**Addendum No. 2**

RE: Contract ID C203148

**Mecklenburg County (P-5208H)**

Grier Road Grade Separation Over Norfolk Southern/NC Railroad From  
Old Concord Road To South of Orr Road in Charlotte

PLAN SHEET UO-3 CORRESPONDS TO ROADWAY SHEET 4

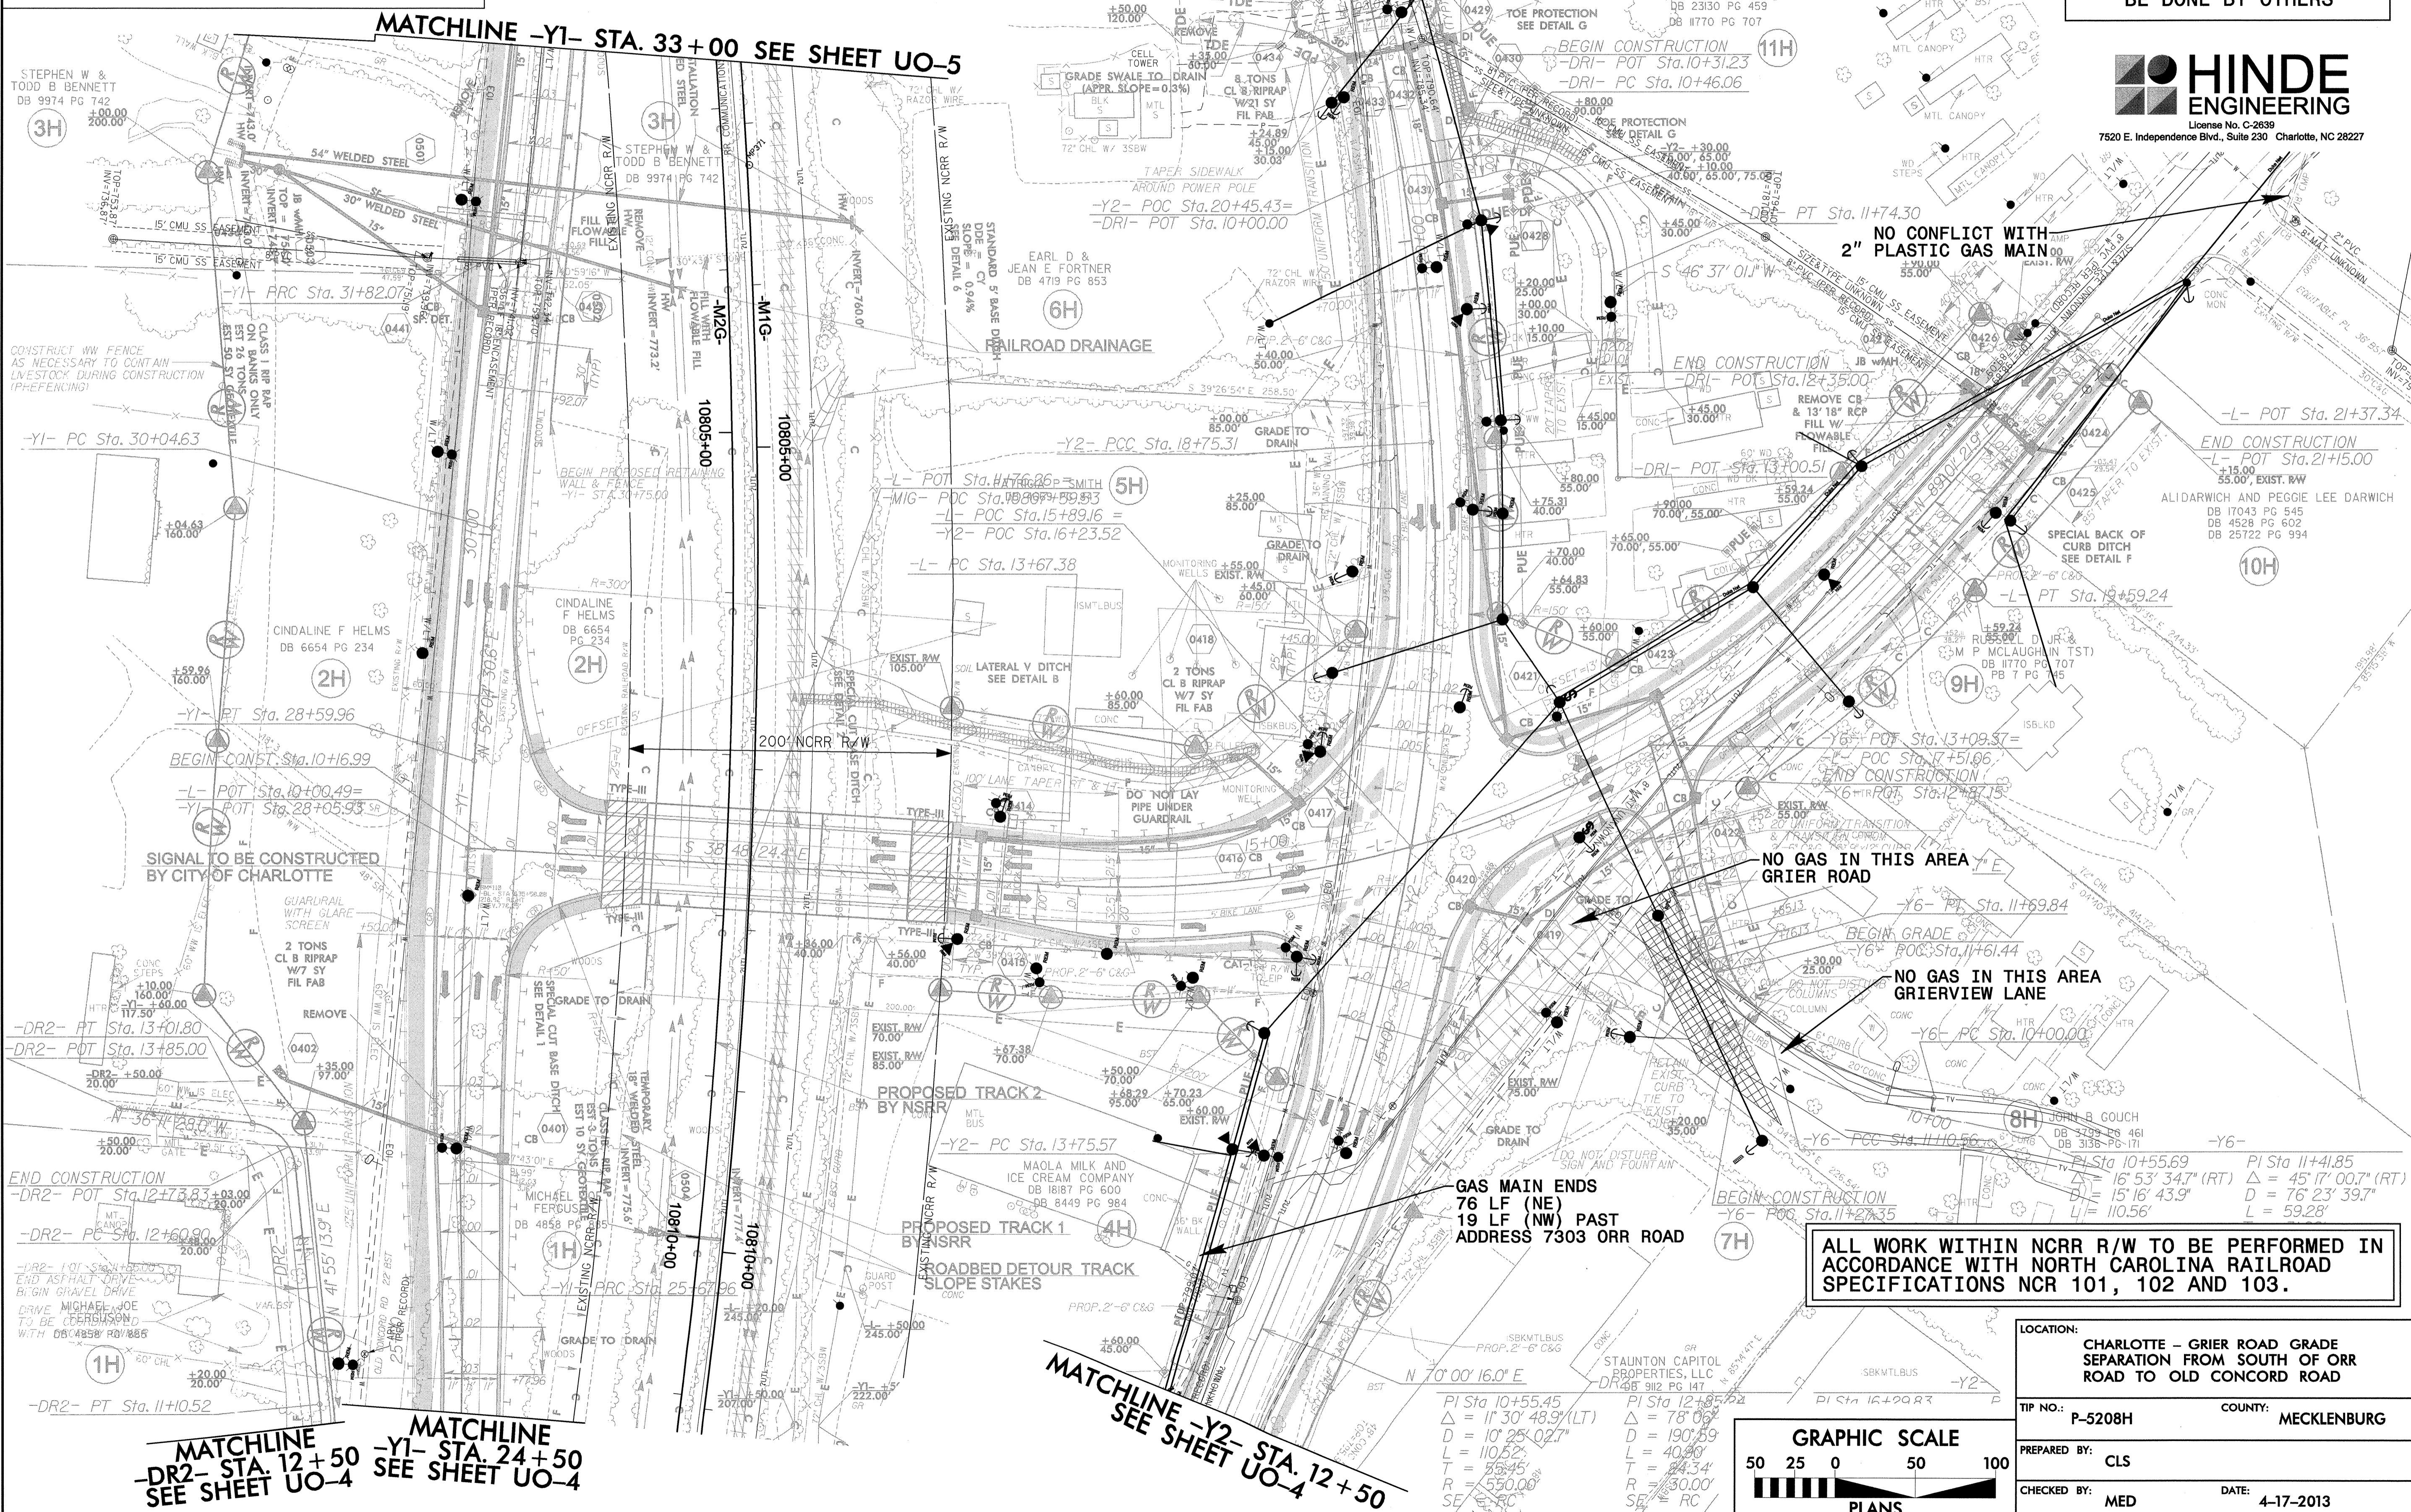
Sheet Nos. UO-1 thru UO-5 have been revised to update utility relocations. Please void Sheet Nos. UO-1 thru UO-5 in your plans and staple the revised Sheet Nos. UO-1 thru UO-5 thereto.
